PROJECT NO. 1002273	APPLICATION NO. 02DRB - 01553
PROJECT NAME DAVIDSON ADDN	
EPC APPLICATION NO.	
APPLICANT / AGENT TOM JOHNSTON	PHONE NO. 255-2052
ZONE ATLAS PAGE G-14	
'WAYNE' 10-15	
<b>ONE STOP COMMENT FORM LOG</b>

RE: Replat of Lots 2 and 3, Block C, Davidson Addition

INDEXING INFORMATION FOR COUNTY CLERK Owner: PROKOPIAK, WALLACE, CHAUVIN LOTS 2-A & 3-A, BLOCK C DAVIDSON ADD SEC 5 T 10 N R 3 E NMPM Albuquerque, Bernalillo County	DRAWN: E W K	SCALE: 1" = 20'	FILE NO. SP-9-03-2002
	CHECKED: T D J	DRAWING NO. SP90302.DWG	27 SEPT. 2002 SHEET 2 OF 2

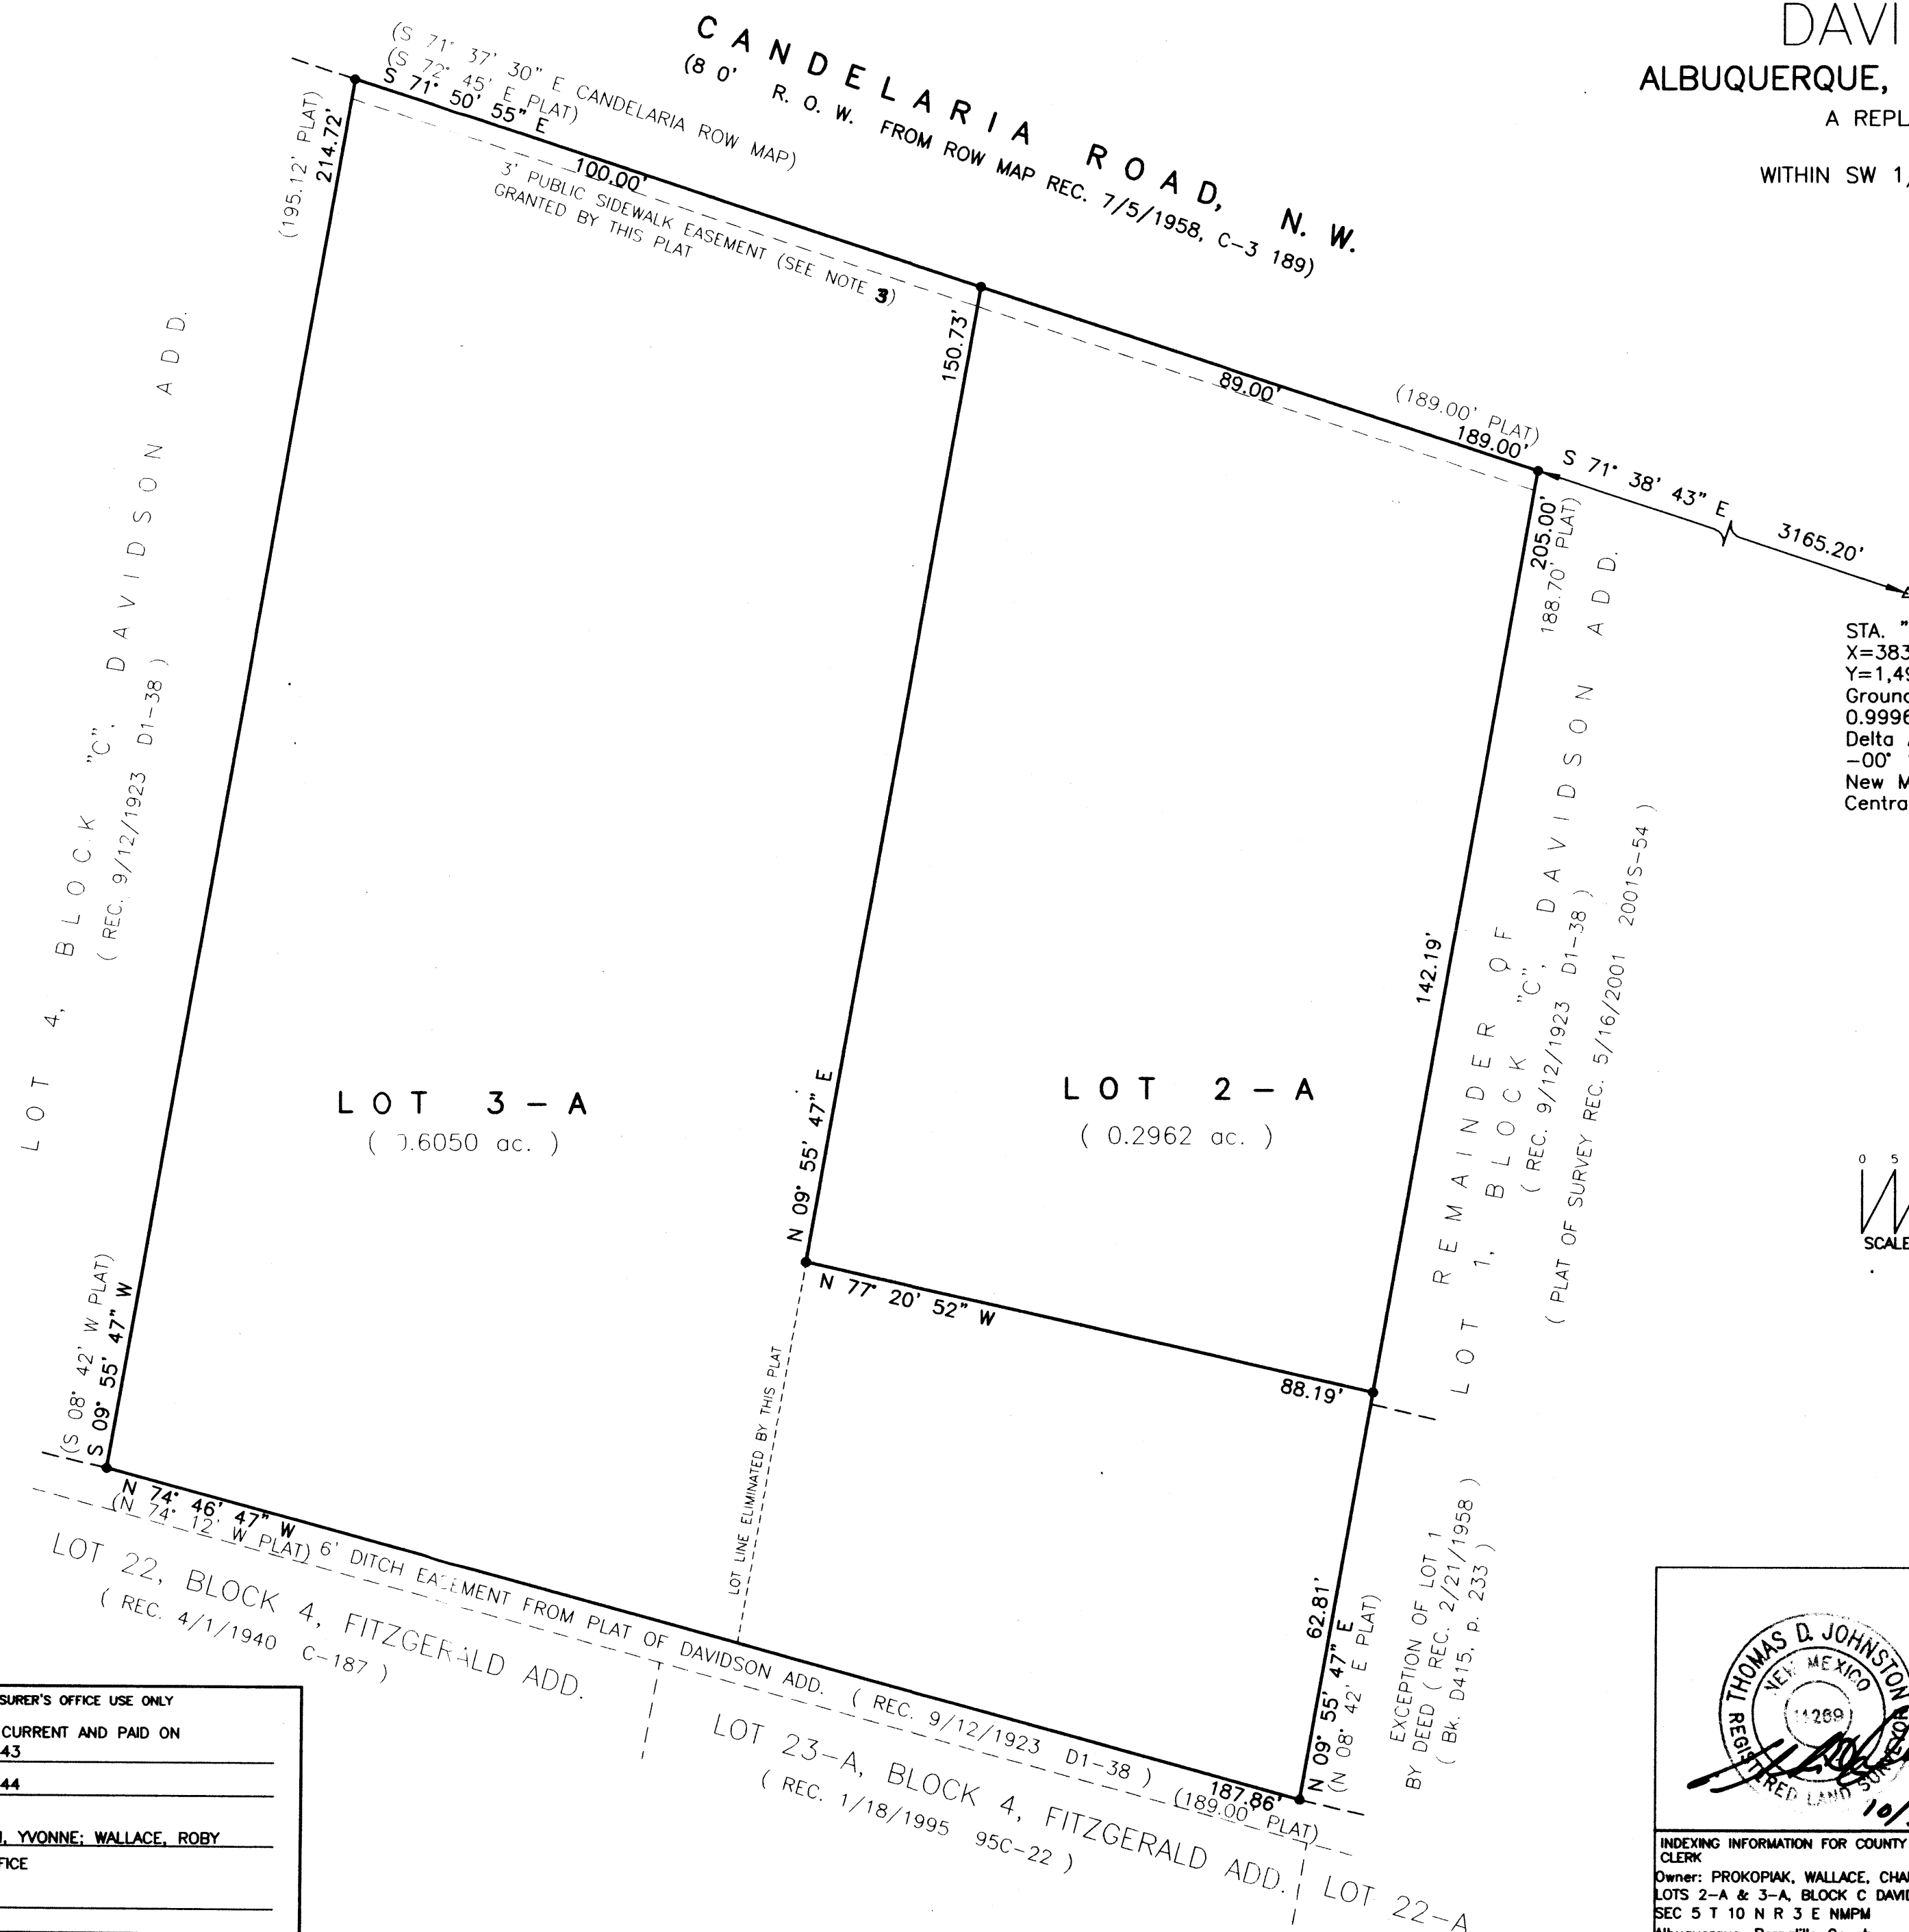
<b>TRANSPORTATION DEV (505) 924-3990</b>		
PLANS DISAPPROVED <del>NSR</del>	DATE 10/10/02 → OK	DATE
PLANS APPROVED NSR	DATE 10/10/02 →	DATE
COMMENTS:		
<p><del>NA total of 10 feet as needed from face of curb to property line. 30' 2.5 feet of ROW dedication is needed to complete the required 10 feet. (3' easement) ok instead of 2.5' ROW</del></p>
